CITY OF ALBUQUERQUE

RE: Lot 12 Block 1 Volcano Cliffs Unit 22 SAD 228
8000 Alto Rey Ct. NW
Grading and Drainage Plan
Engineers Stamp Date: 10/19/2020 (D10D003N12)
CO Certification Date: 3/11/2021

SHEET TITLE: GRADING AND DRAINAGE PLAN

SHEET TITLE: GRADING AND DRAINAGE PLAN

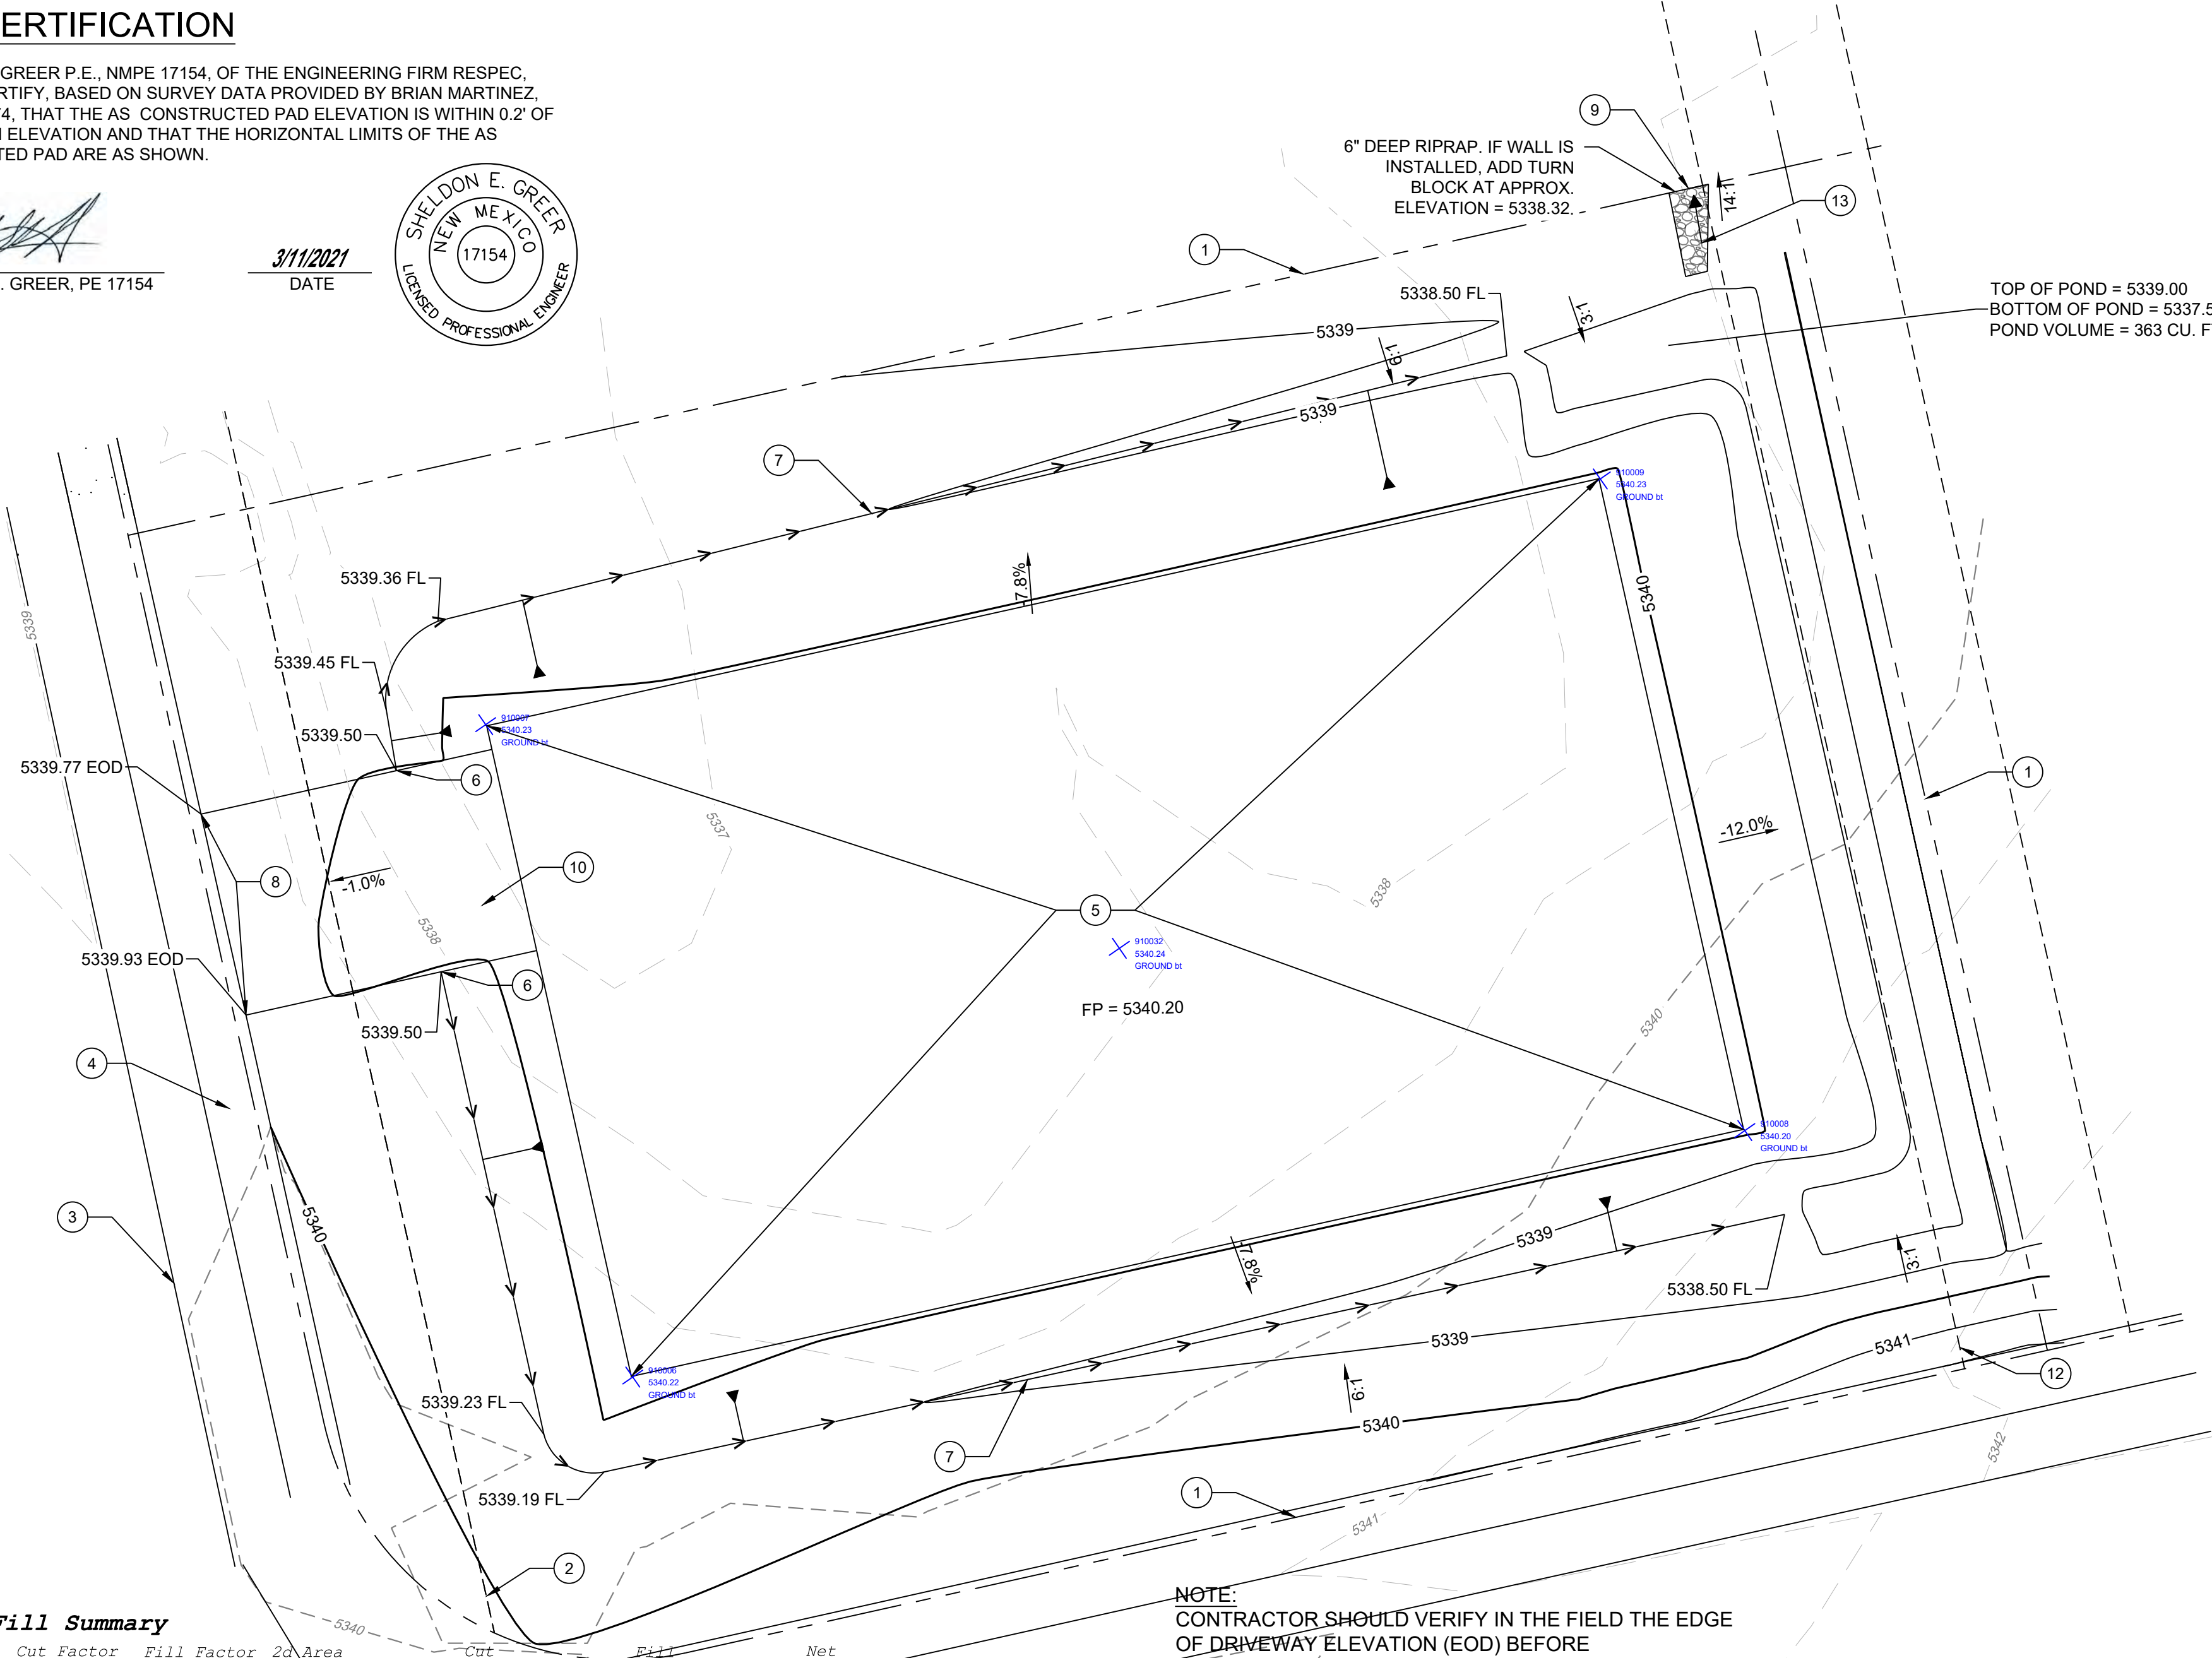
- Lot did not have an address, provide address
- Have all dirt ramps removed from the streets. Crusher fines or lumber are to be used for driving over a curb.
